**RE-REAR EXTENSION TO STORAGE AND WORKSHOP AREA & ROOF
EXTENSION TO MAIN UNIT REAR OF HOLMLEA, TOWN CROSS AVENUE
PO21 2DN ref BR/288/17/PL**

Proposed East Elevation

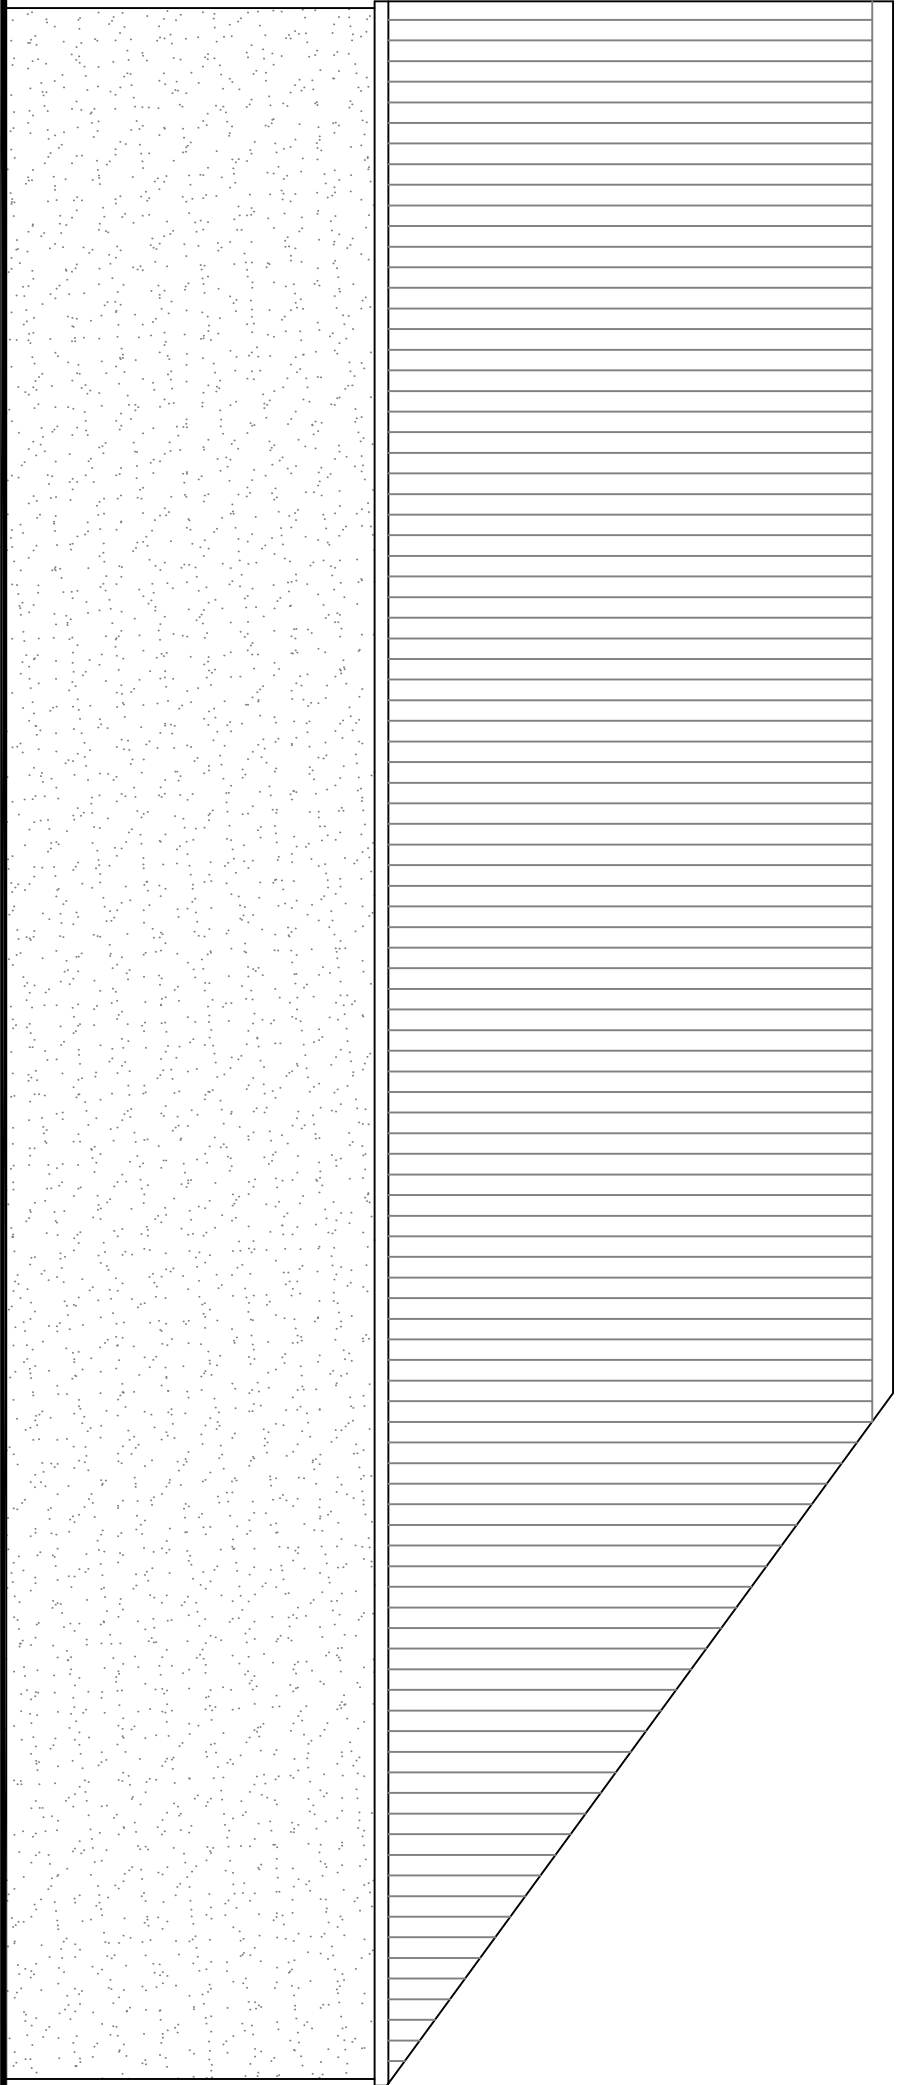
The plans show the side of the proposed upper floor east building will be facing my back garden, therefore I will also be overlooked by this business, removing the last bit of privacy my property has at this time, this would also reduce natural light to my property as the building is currently on one level.
